**Planning Application No: 3/2024/0657**

**Proposal:** Approval of details reserved by conditions 11 (Construction Traffic Management Plan), 12 (Details of site access and off-site works) and 18 (Surface Water Drainage Scheme) of planning permission 3/2023/0956.

**Location:** Ravenscourt, Neville Street, Longridge PR3 3FD

**CONSTRUCTION  
PHASE SITE PLAN-1**

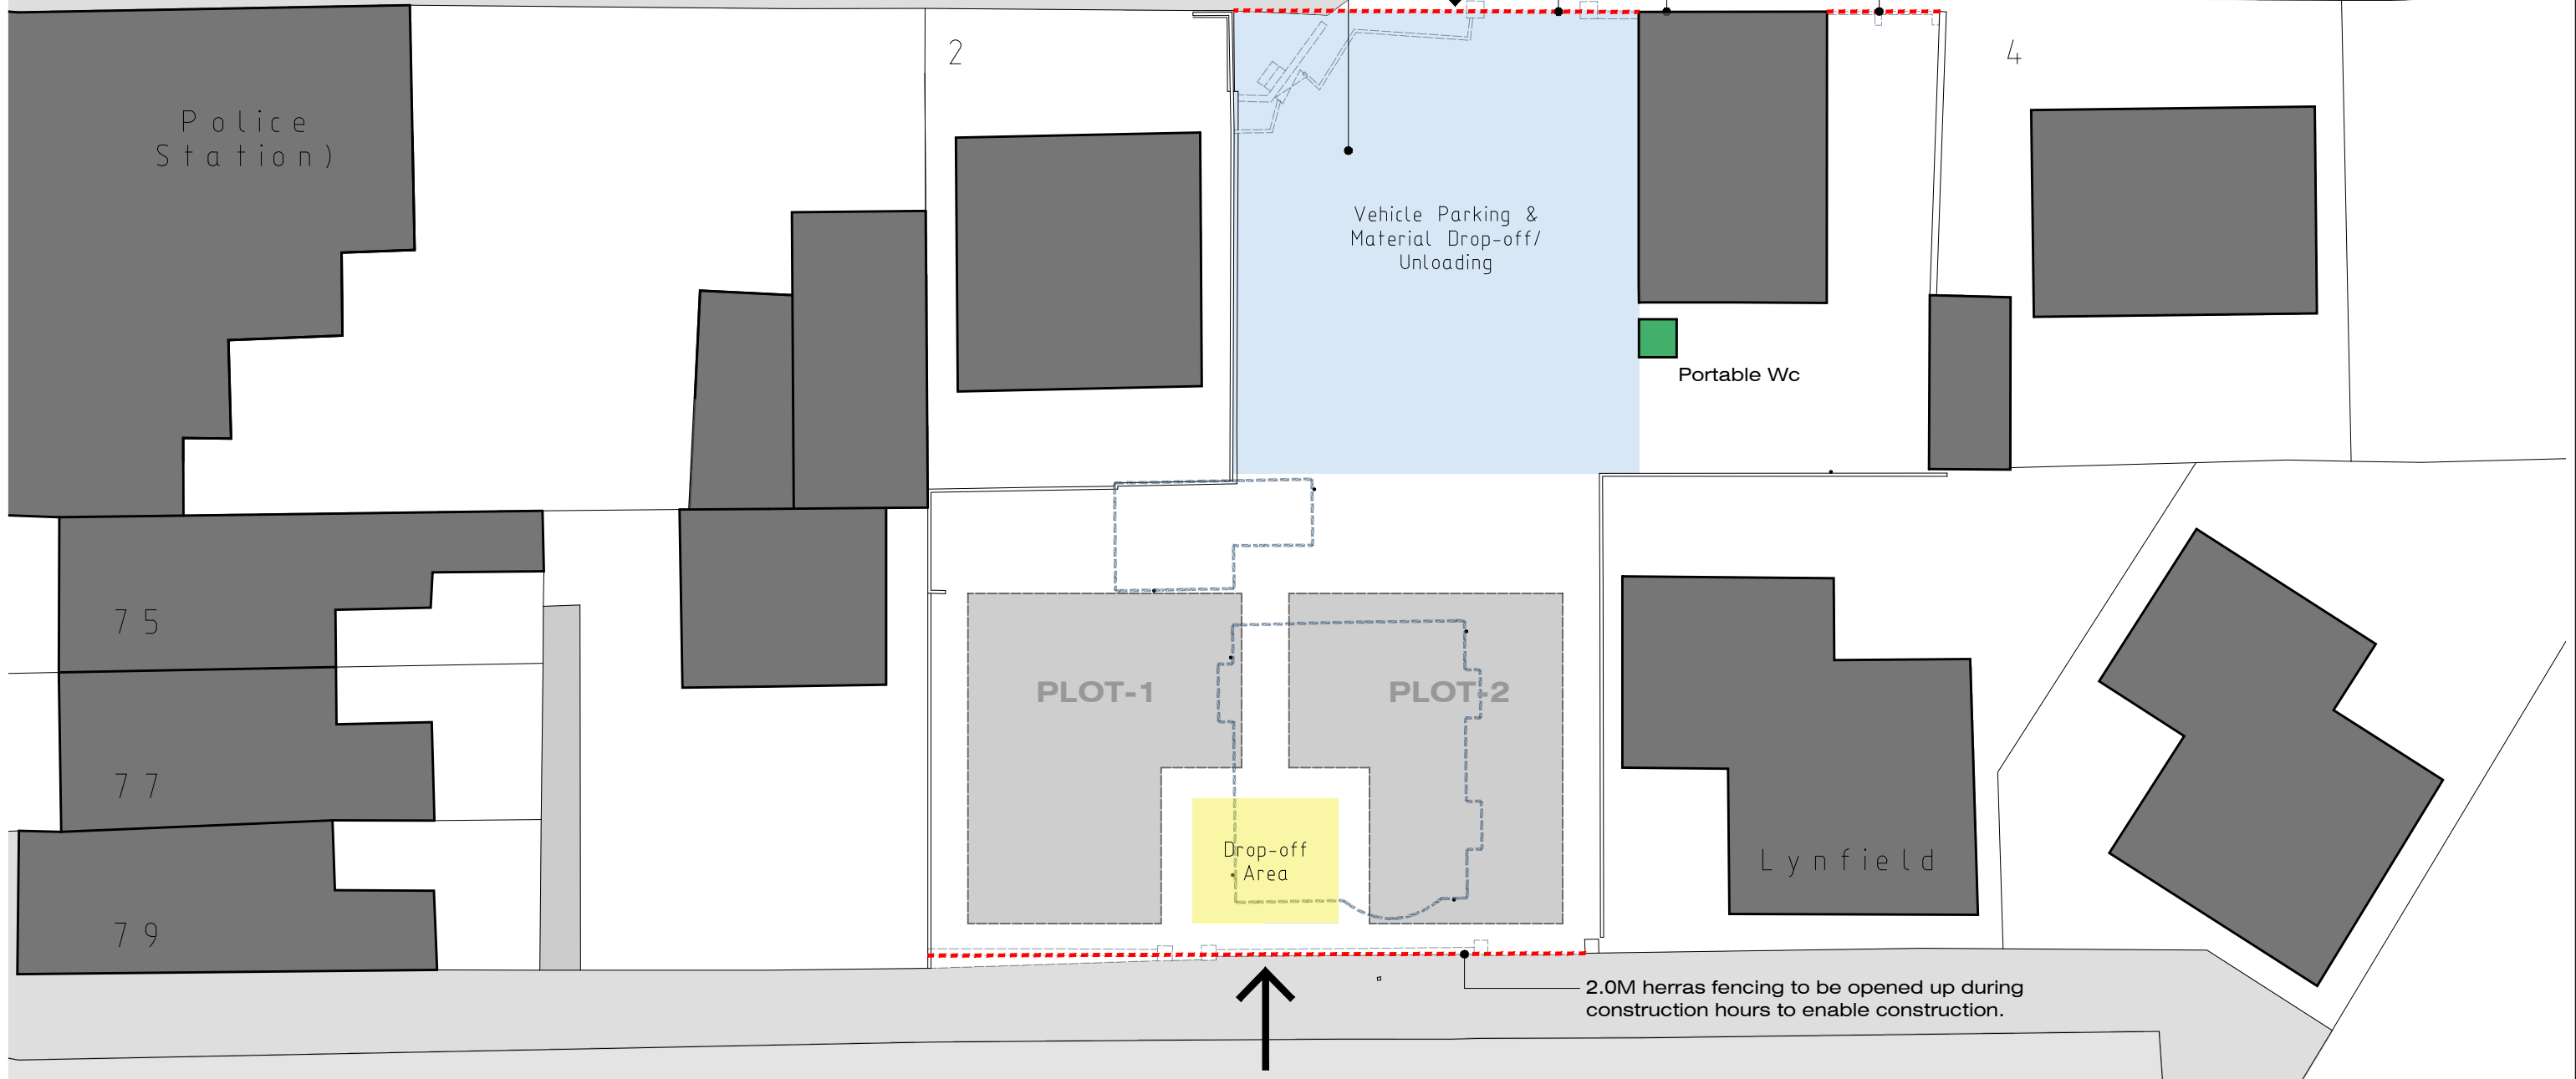
Construction Phase Site Plan -1 (Drawing JM-0263 008), Construction Phase Site Plan - 2 (Drawing JM-0263 009) and Construction Traffic Management Plan (no reference) have been submitted to discharge the above condition. Having reviewed these documents the highway authority makes the following comments.

Phase I construction – vehicular access to the site should be via the existing dropped vehicle crossing on Fleet Street to protect the construction of the footway. Access gates in the boundary Herras fencing should be erected to correspond with the crossing.

DEVELOPMENT OF LAND: RAVENSCOURT NEVILLE STREET LONGRIDGE PRESTON PR3 3FD	JM-0263	009	Date: 18.07.24 Drawn: J Monks Scale: 1:200 Size: A3
	CONSTRUCTION PHASE SITE PLAN-2		
MONKS-ARCHITECTURAL-DESIGN			
25 BIRCHFIELD DRIVE - LONGRIDGE- PRESTON - PR3 3HP

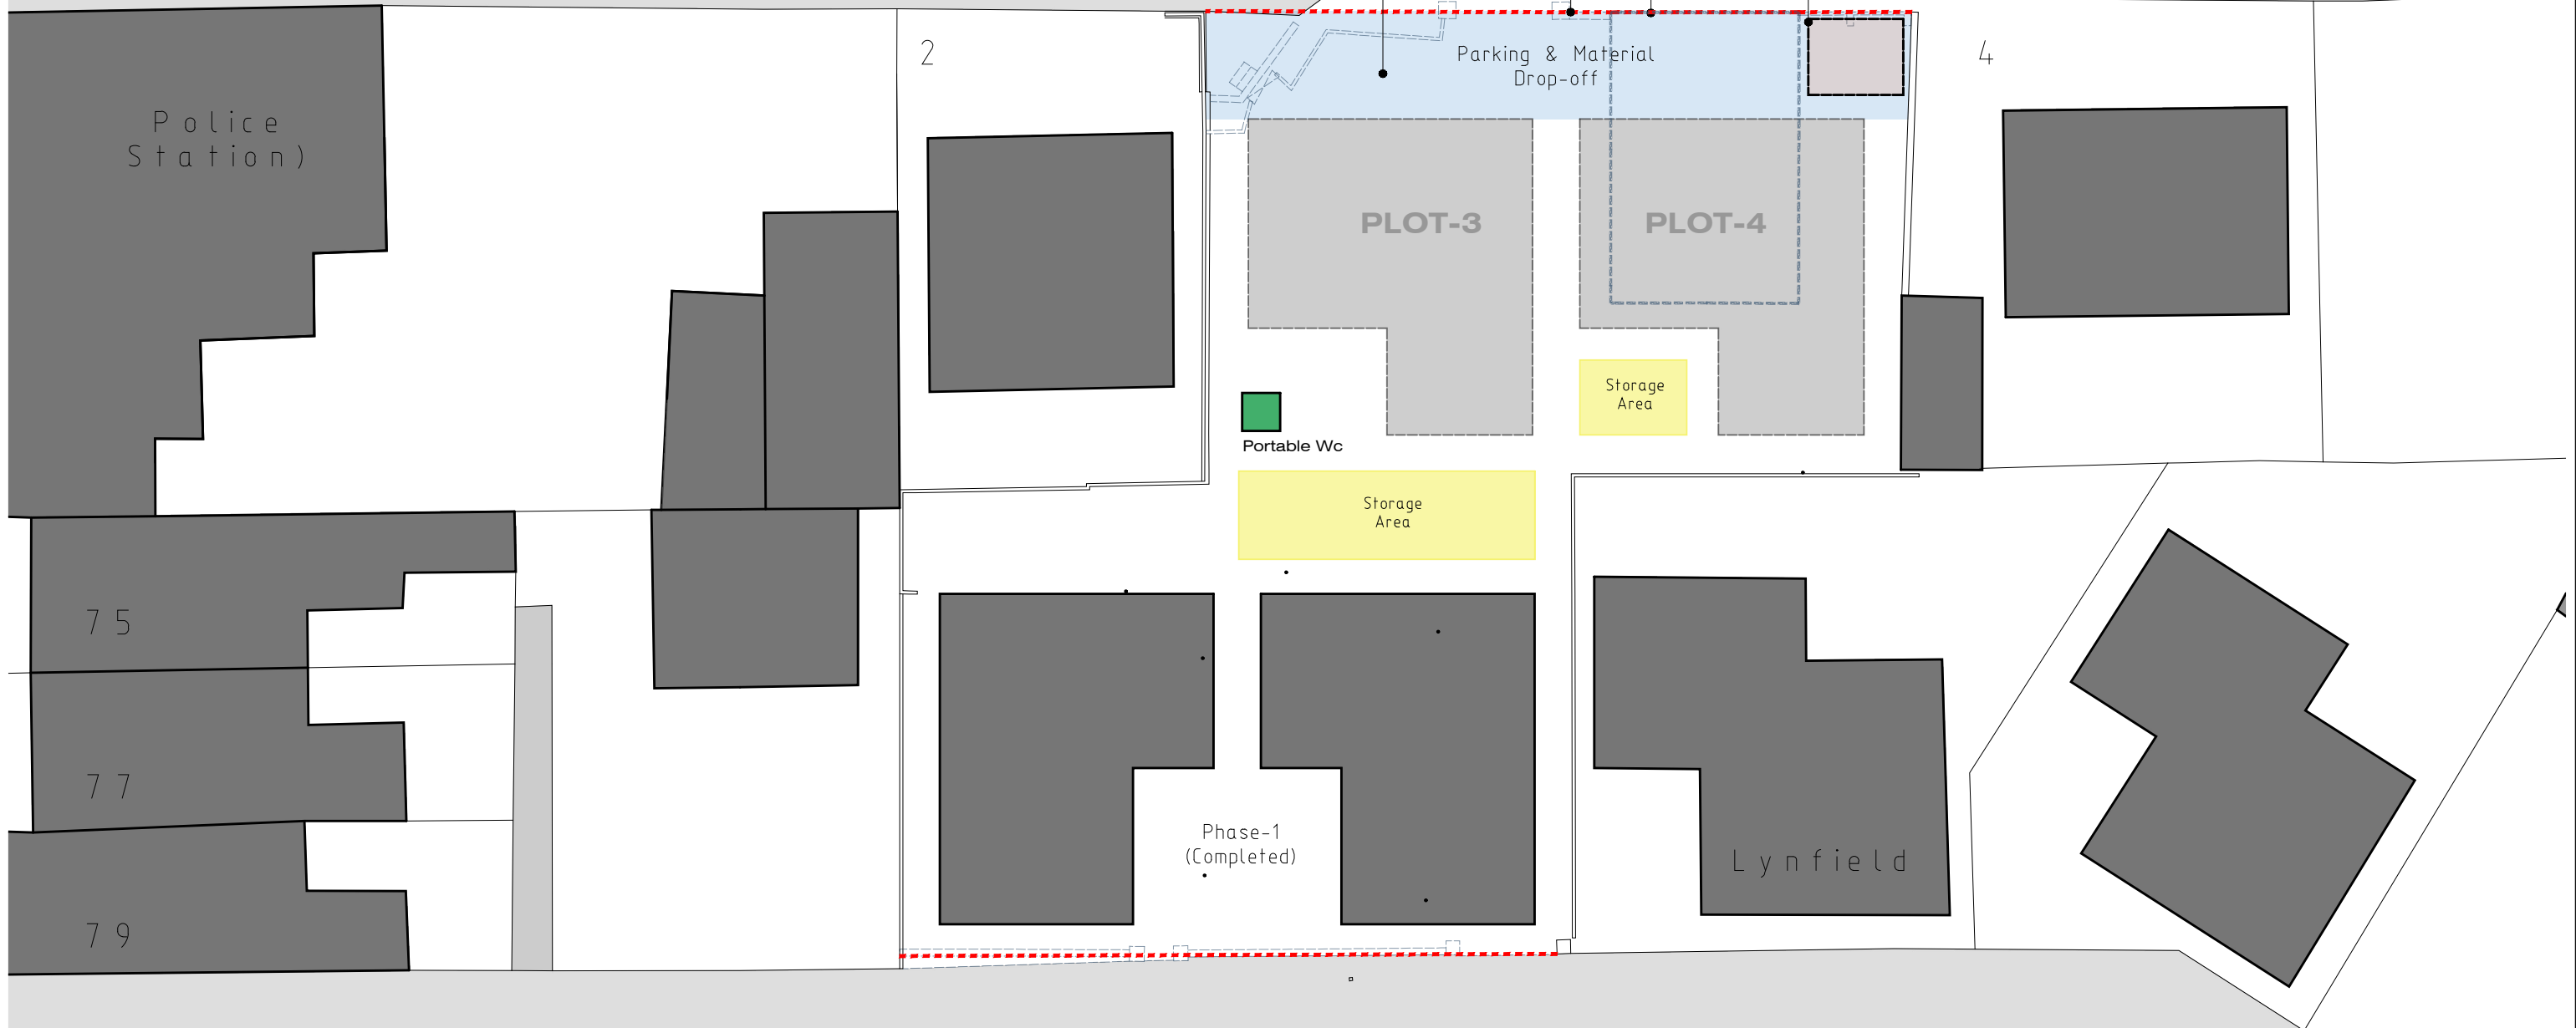
Phase II – there are concerns about the very limited on-site parking for site operatives accessed from Fleet Street. The highway authority notes the proposal that vehicles may need to be moved off-site temporarily to allow deliveries. However, no vehicles associated with the development must park permanently on Fleet Street or Neville Street during the construction or fitting out phases.

PROPOSED OFF-SITE CONSTRUCTION DETAILS (DISCHARGE OF CONDITION 12)

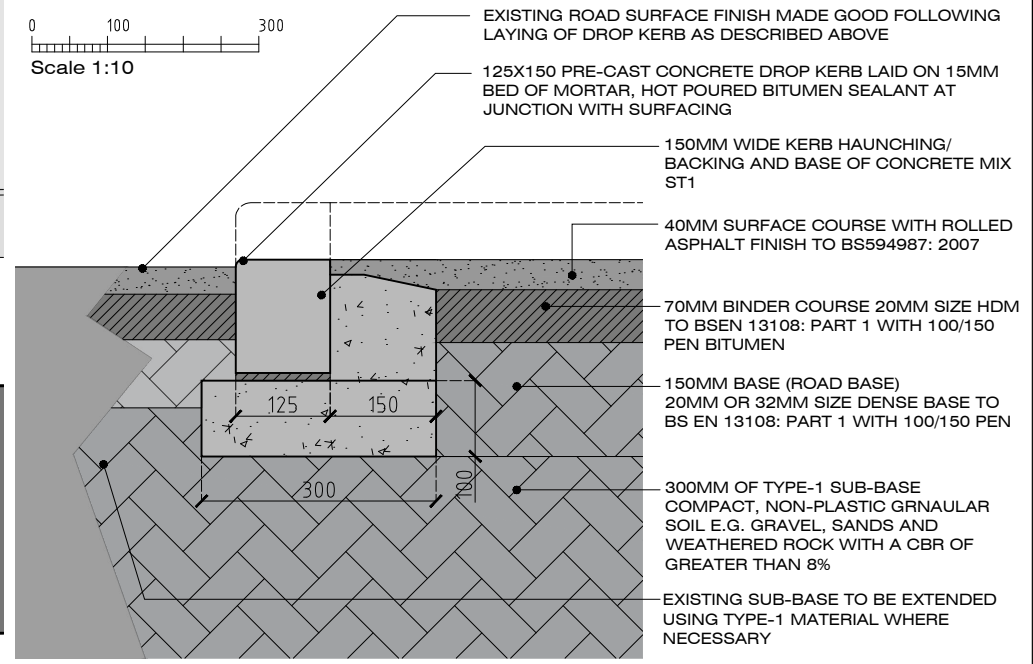
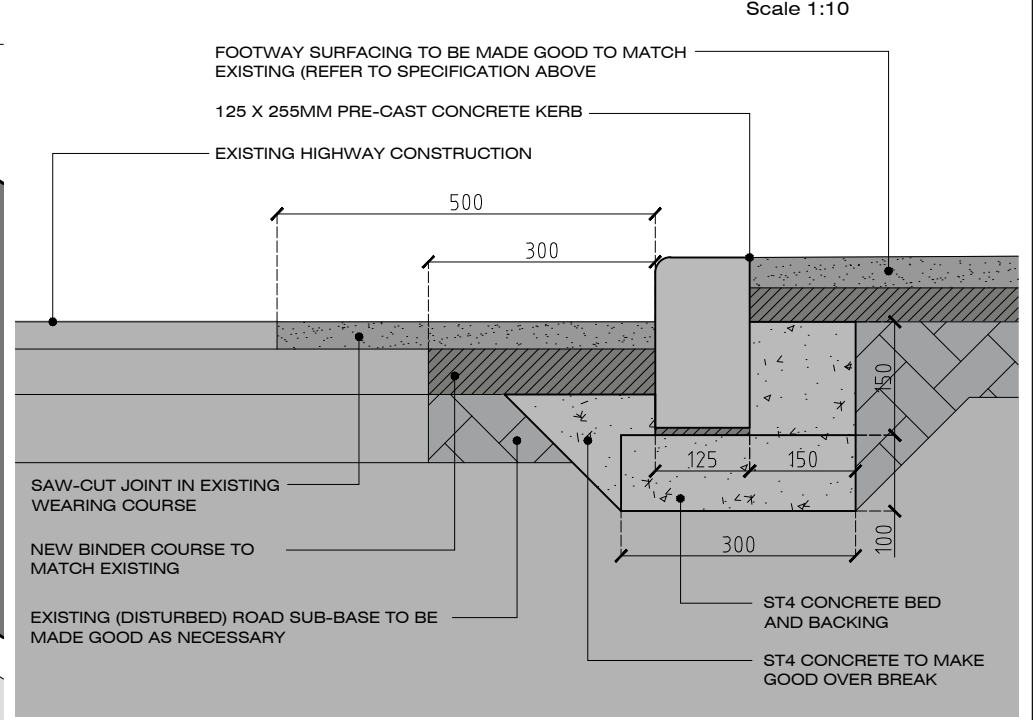
Proposed Off-site Construction Details (Drawing JM-0263 010 Rev C) have been submitted to discharge Condition 12. The highway authority considers that this condition cannot be discharged at this time.

The proposed scheme for highway works is not acceptable as it is not to Lancashire County Council's specification. Further information required to discharge this condition, including details of the correct specifications, can be obtained from the Highway Development Control Section by emailing the team mailbox – [developeras@lancashire.gov.uk](mailto:developeras@lancashire.gov.uk) – quoting the relevant planning permission reference number.
